From:
Sent: 30 July 2026 00:18
To: DC Admin
Subject: RE: Urgent representation – application 2026/92032, Land off Birkby Road

Please add the following as a further formal representation on application 2026/NMA/92032/W and forward it specifically to the case officer, Ellen Gilbert, before the application is determined.

Drawing no
Site Plan as Proposed

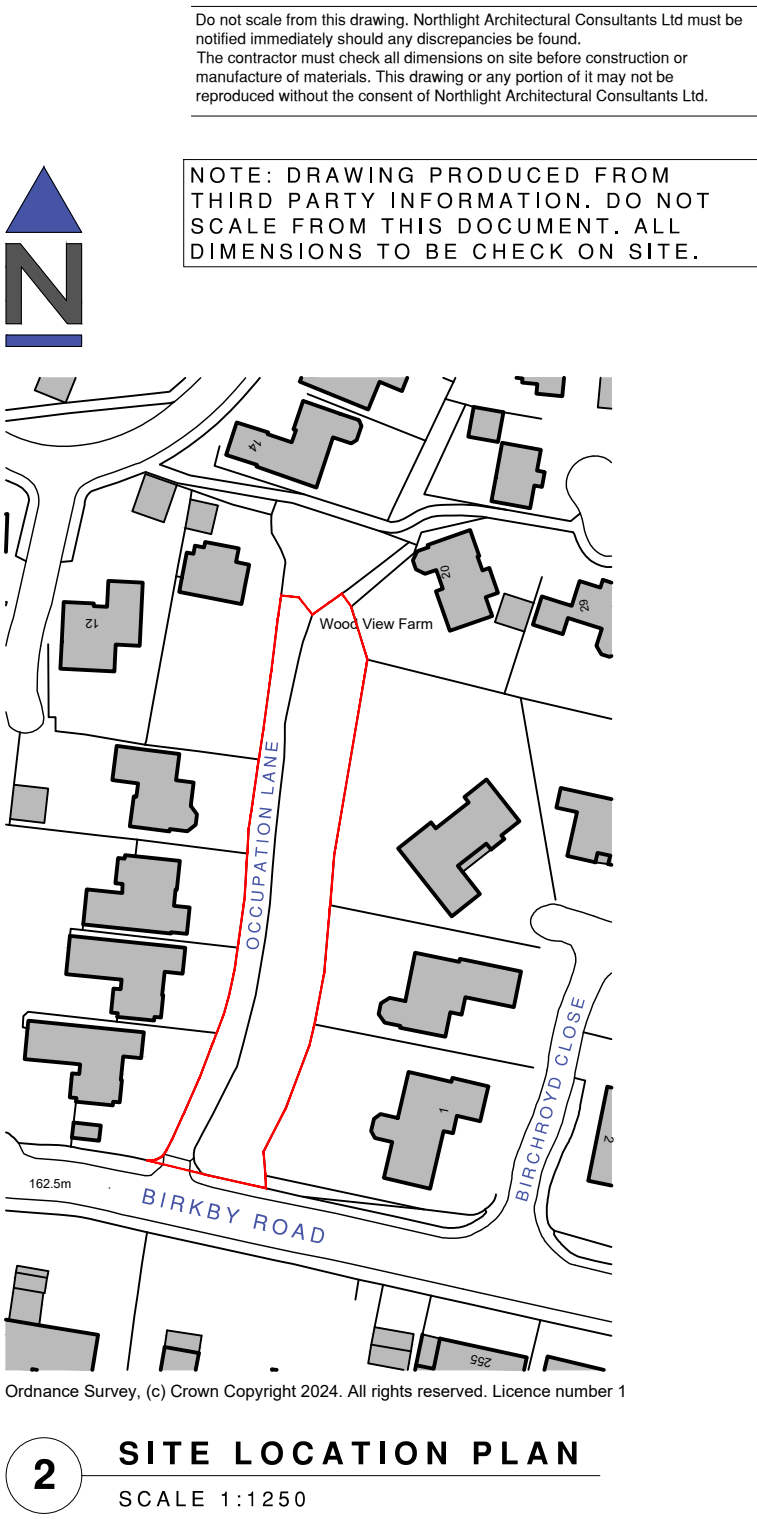
For clarity, I do not own the relevant section of driveway. My property, , benefits from a registered vehicular and pedestrian right of way over it. My planning concern is that the drainage appears to be installed within, beneath or immediately beside that access route and may affect its width, stability, surface-water behaviour, underground services, future maintenance and safe emergency access.

The driveway has historically been free-draining and has not previously had drainage in this position. I have not been able to identify a clear drainage route, specification or discharge point on the published planning drawings. If the pipe serves the new development, its position relative to the development boundary and access route must be established. If it is said to serve the driveway, the applicant should explain why it is required, where it discharges, who authorised it and who will own and maintain it.

This is directly relevant to the current amendment because the application states that the layout was changed following “new legal boundary information” so the dwelling could be constructed within the applicant’s legal boundary. It also seeks changes to the dwelling, garage and overall site arrangement. The location and purpose of additional drainage beside the access route may therefore affect whether the combined changes can properly be regarded as non-material.

1. the drainage construction drawing and discharge details have been supplied; 2. the pipe’s surveyed position relative to the development boundary and right-of-way route has been established; 3. the effect on access, ground stability, services, surface water and maintenance has been assessed; 4. the Council has confirmed whether the drainage accords with the approved and amended plans; and 5. Planning Enforcement and Building Control have had an opportunity to inspect the work before it is concealed.
